From: Thomas Callaway
Sent: 11 November 2013 16:27
To: Planning.Responses
Subject: RE: Planning Consultation on: Y/87/13/

APPLICATION **Y/87/13/**

Site Address: Land Southwest of Drove Lane Farm Yapton

Description of Works: Installation of solar farm comprising erection of solar arrays,
inverters, transformers, equipment housing, security fencing,
internal tracks & ancillary equipment

Panel Detail A (not to standard scale)

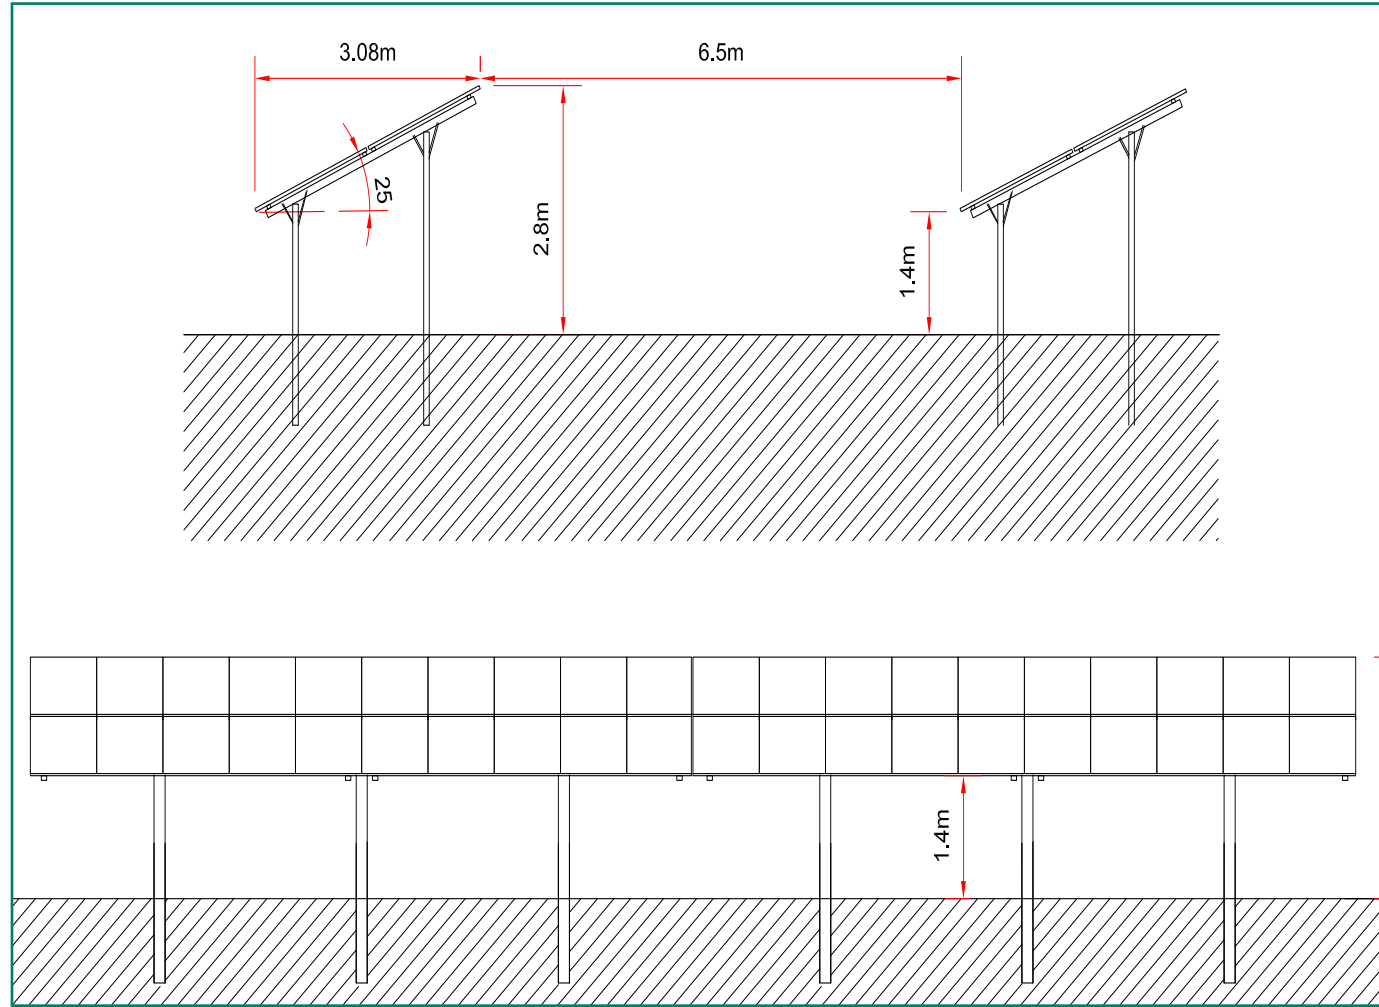
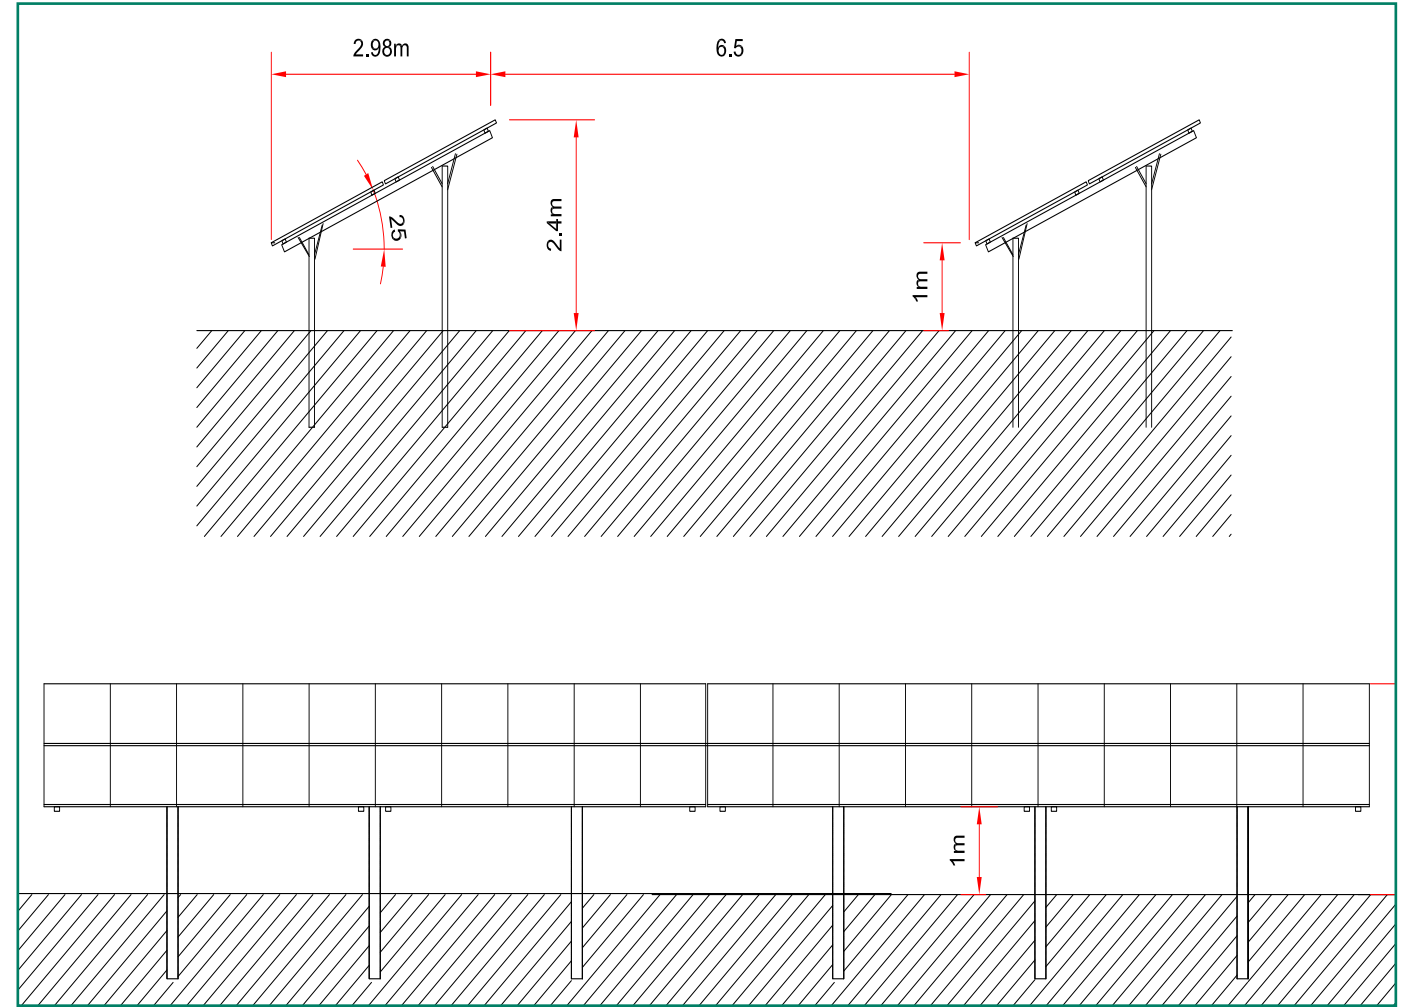
We have noted that infrastructure is proposed to be installed above future flood levels. A suitable maintenance strip should be set aside adjacent to all ditches on the site. Provisions for draining the runoff from the PV panels should be introduced to reduce the erosion of the grass beneath the lower edge of the panels.
